Rezoning Transportation Analysis
Petition Number: Insert Zoning Petition #2021-226
General Location Identifier: 02902129, 02902130

Date	Description
02-24-22	First Review (PDM)
03-24-22	Second Review (PDM)
04-27-22	Third Review (PDM)

**Appalosa Real Estate Partners
Development Standards
4/20/22
Rezoning Petition No. 2021-226**

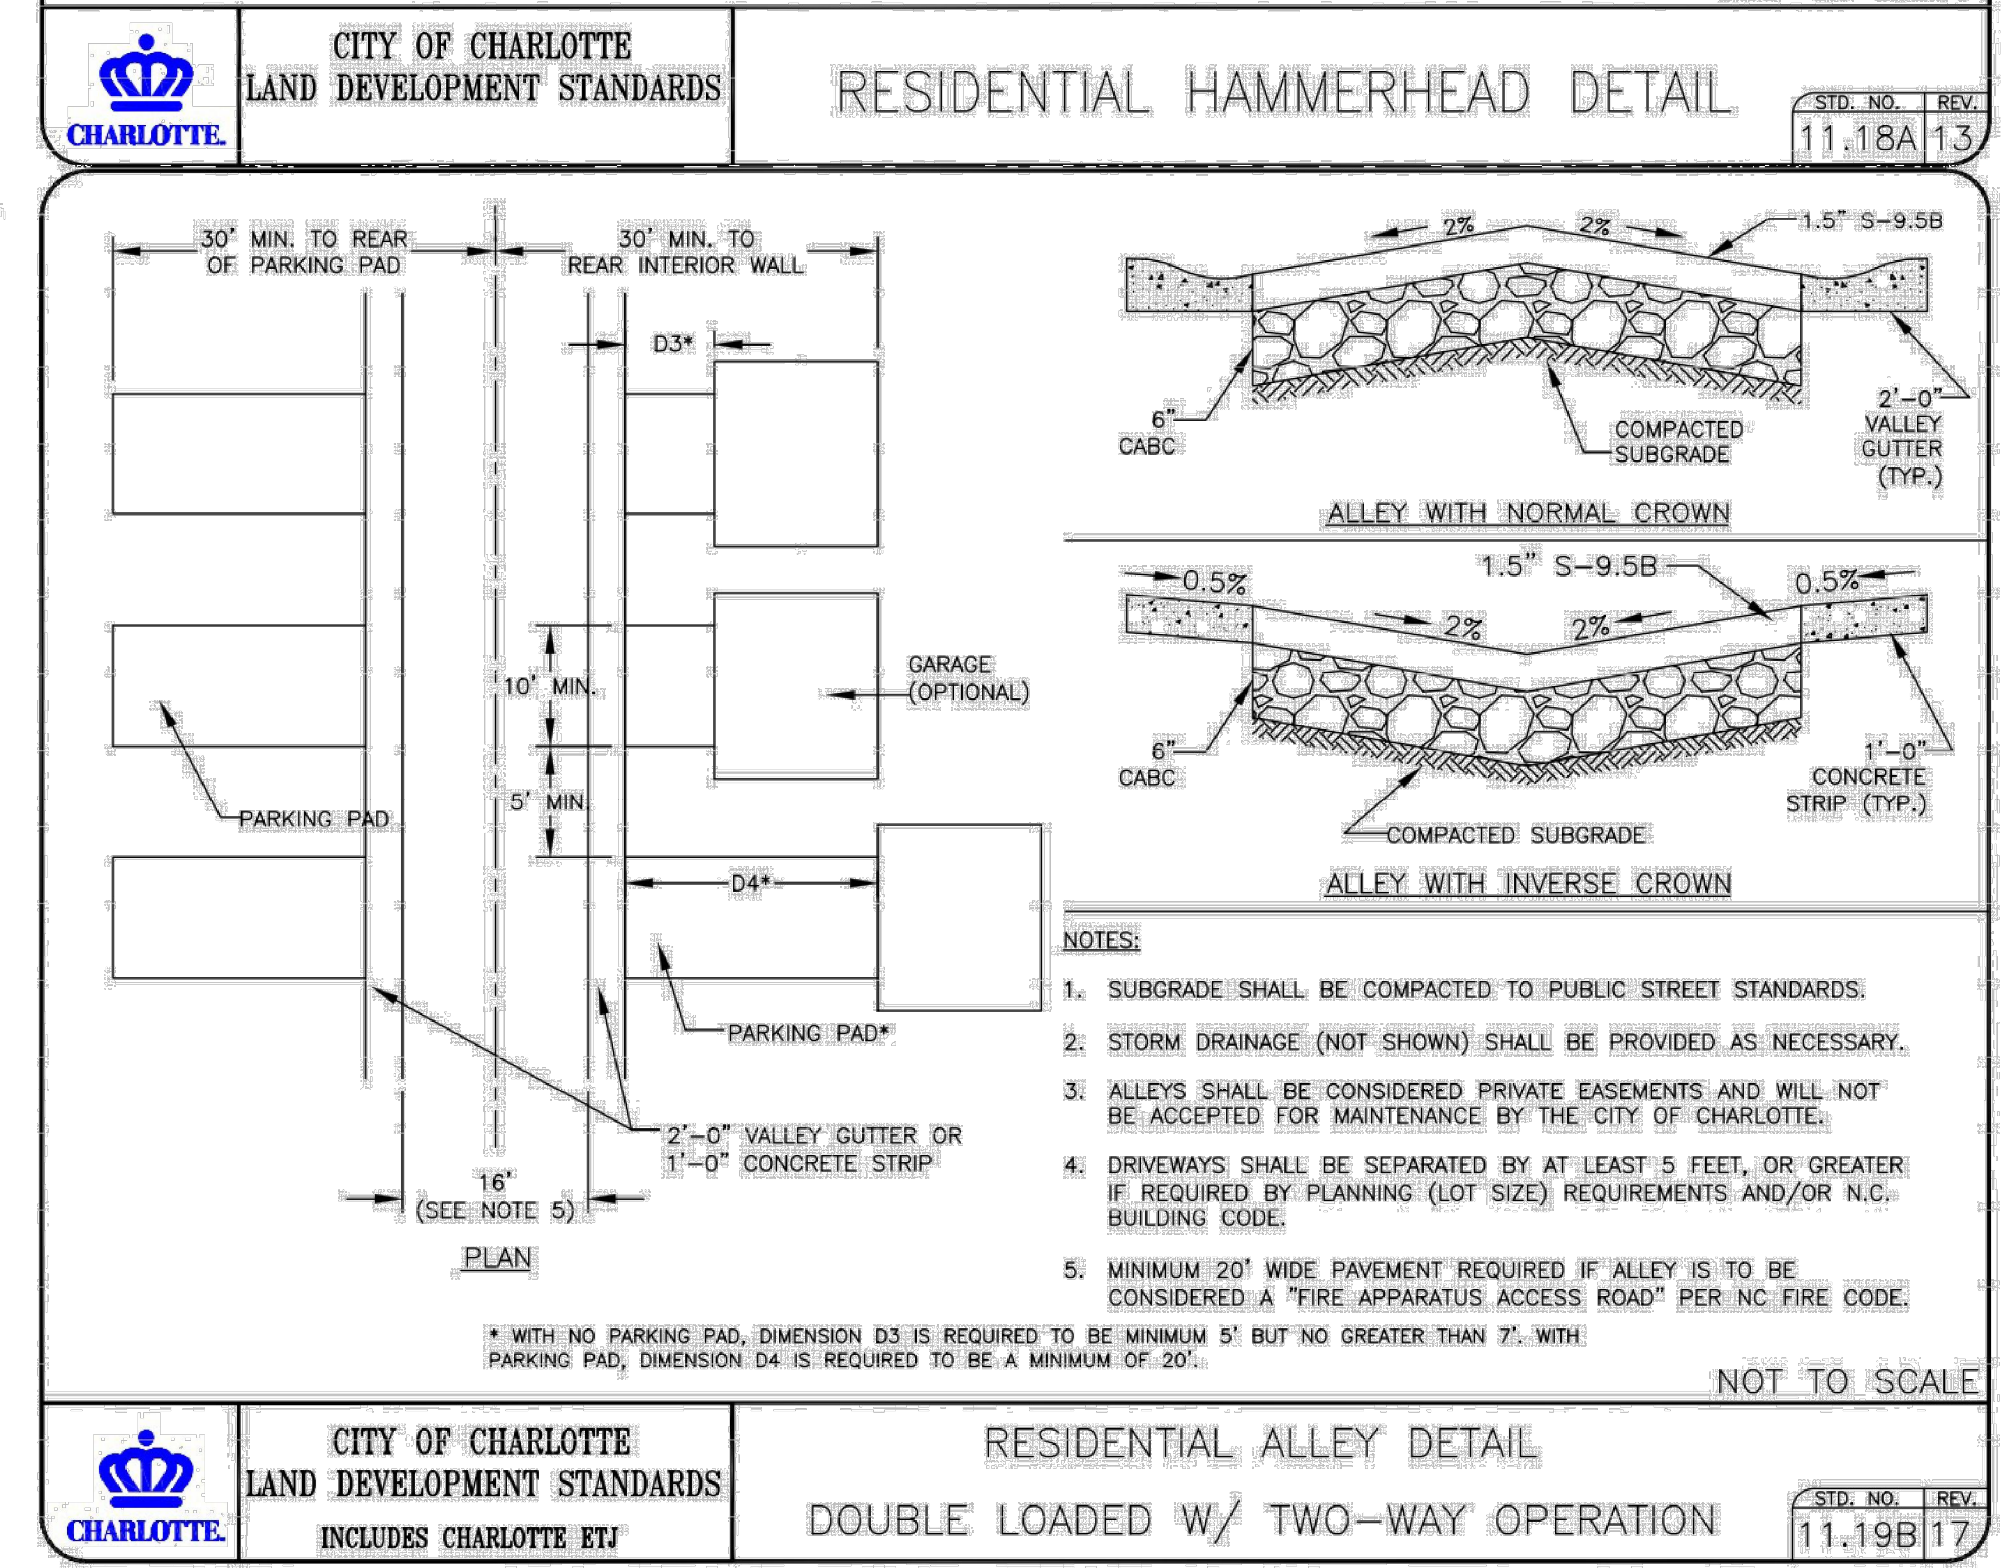
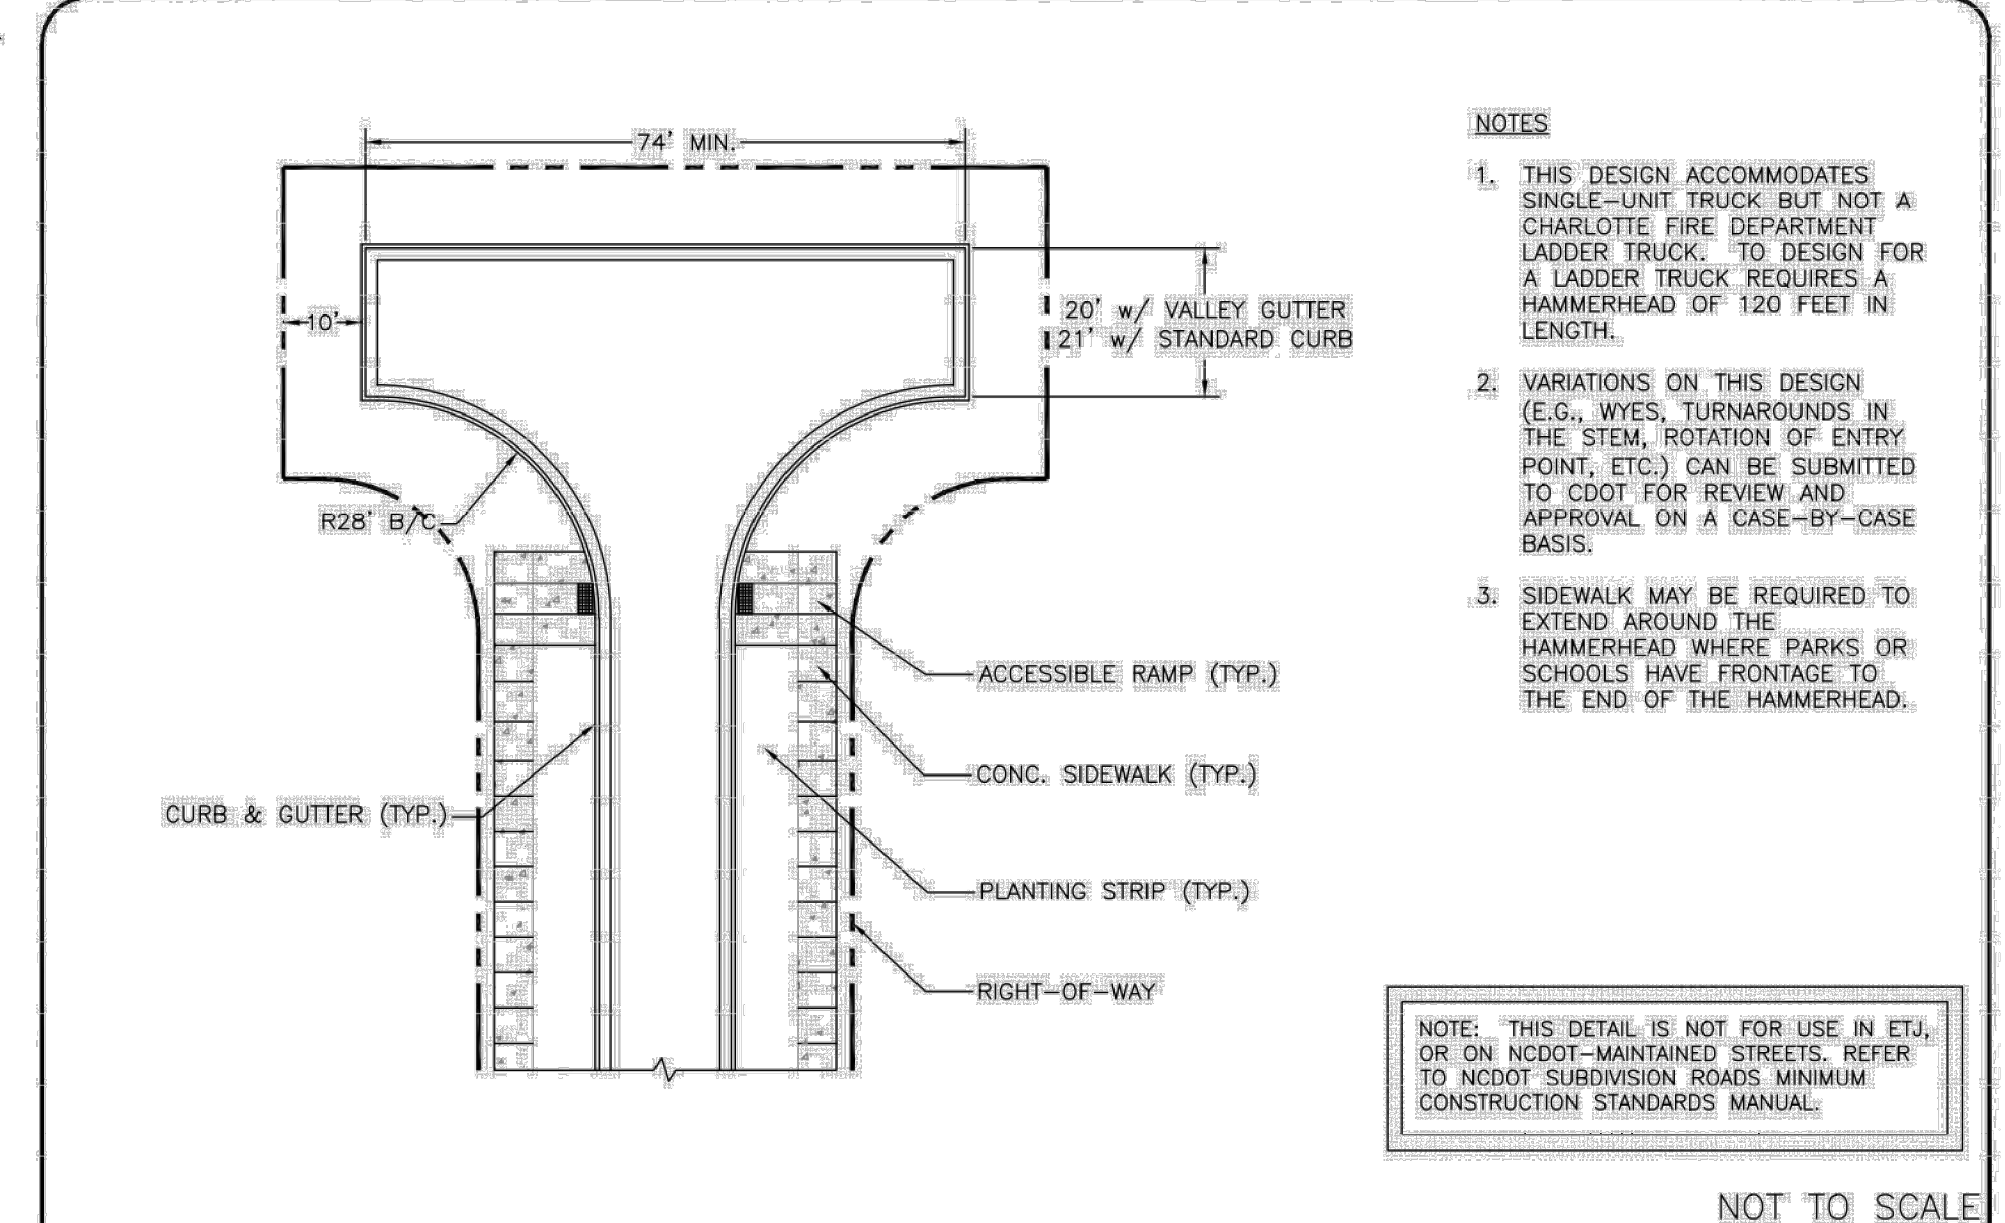
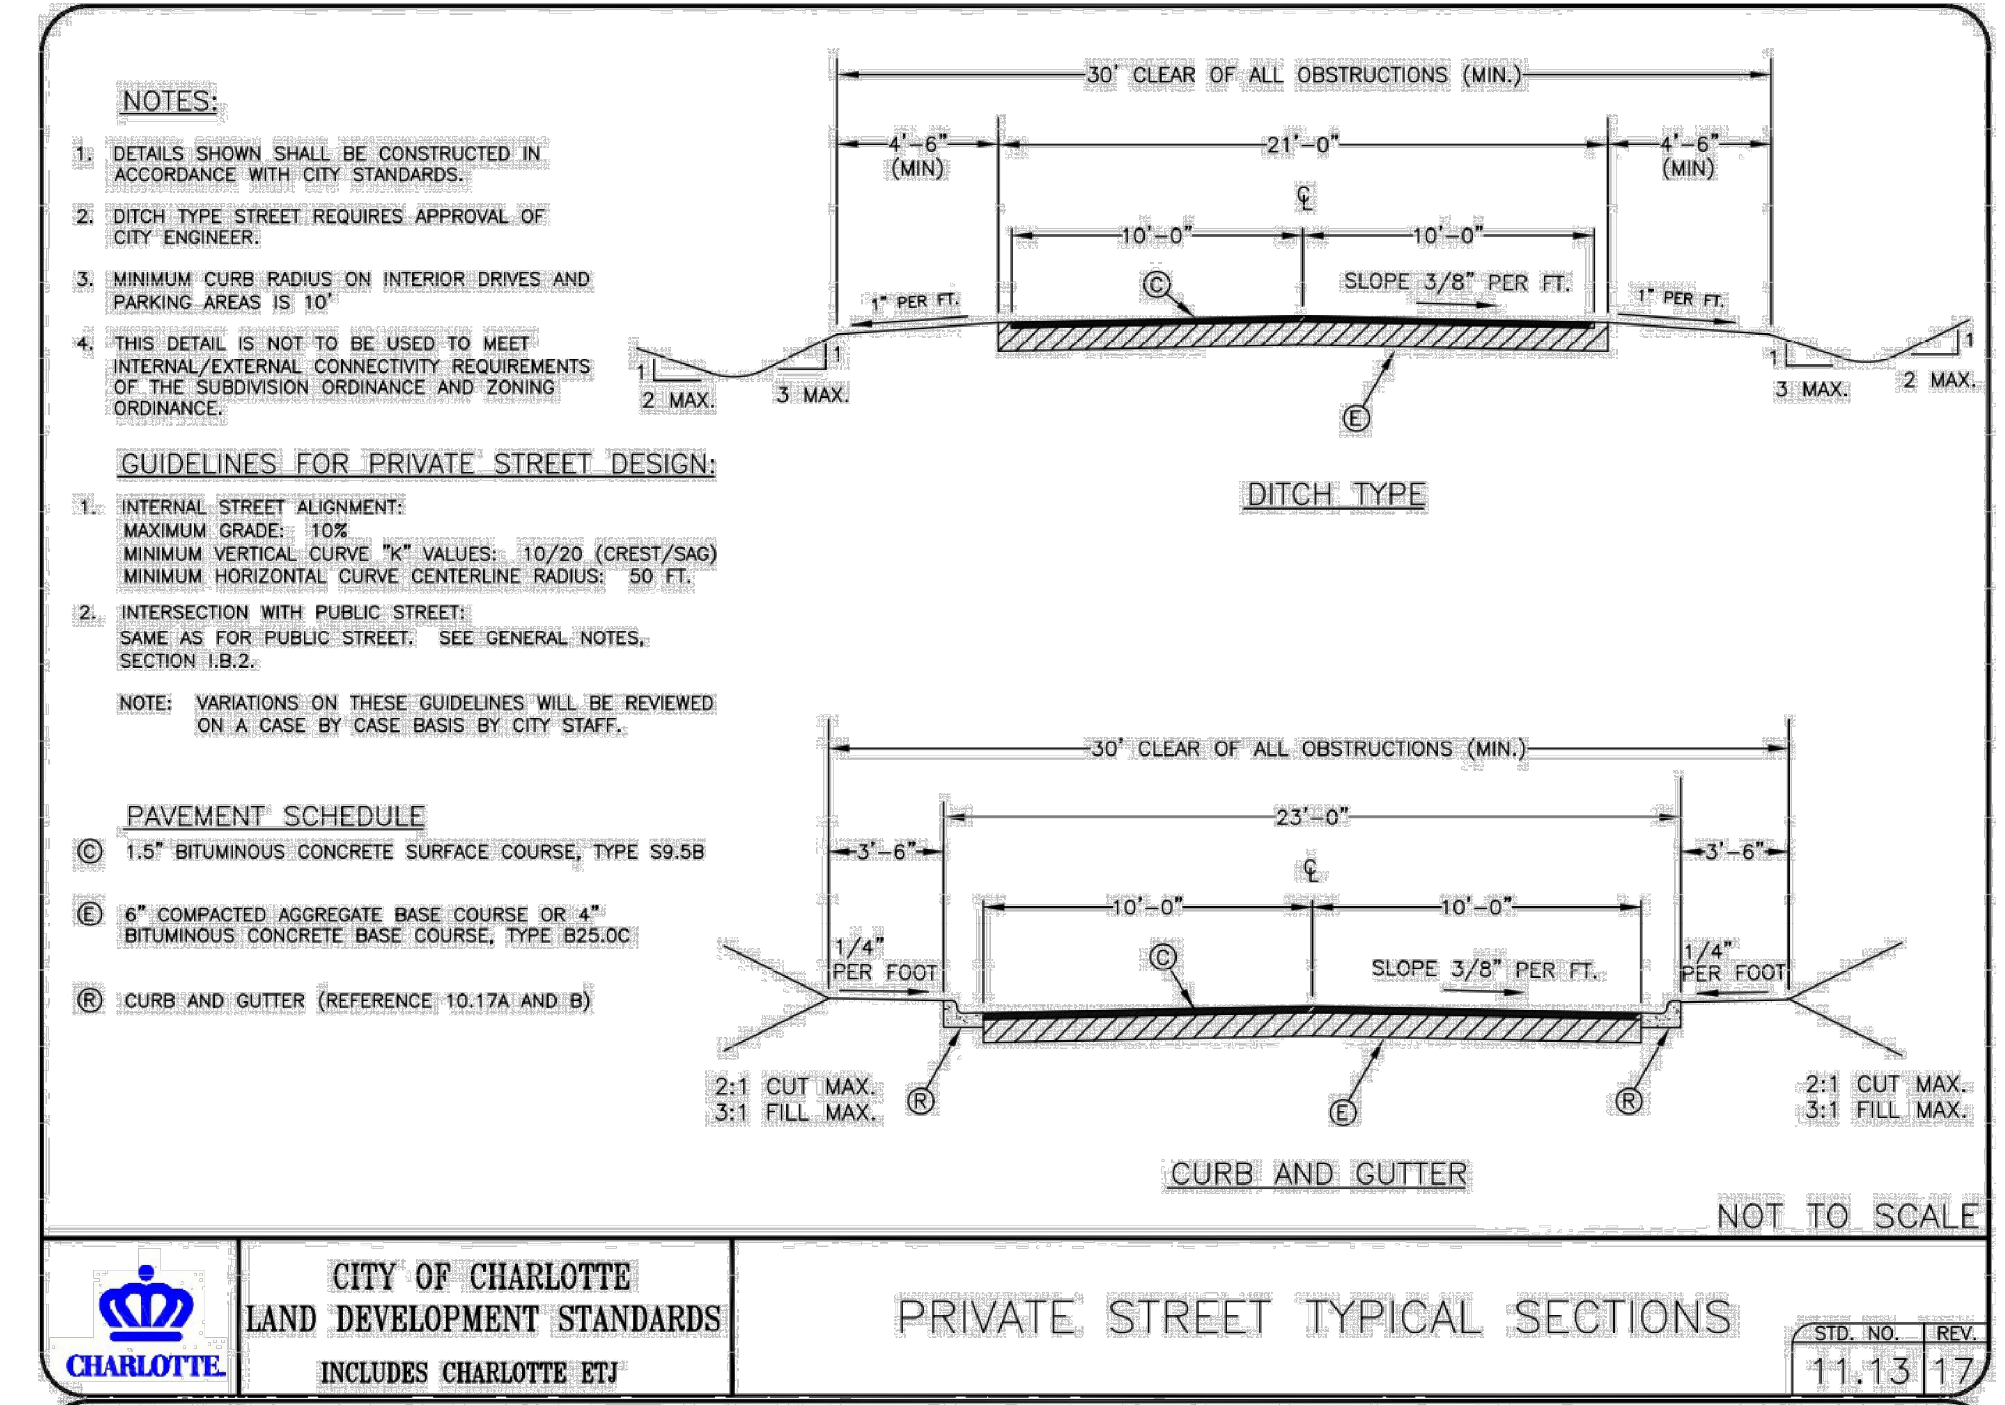
9. ~~Rescinded Comment from 02.24.2022:~~ Remove language from conditional note 3.H per the markup below.
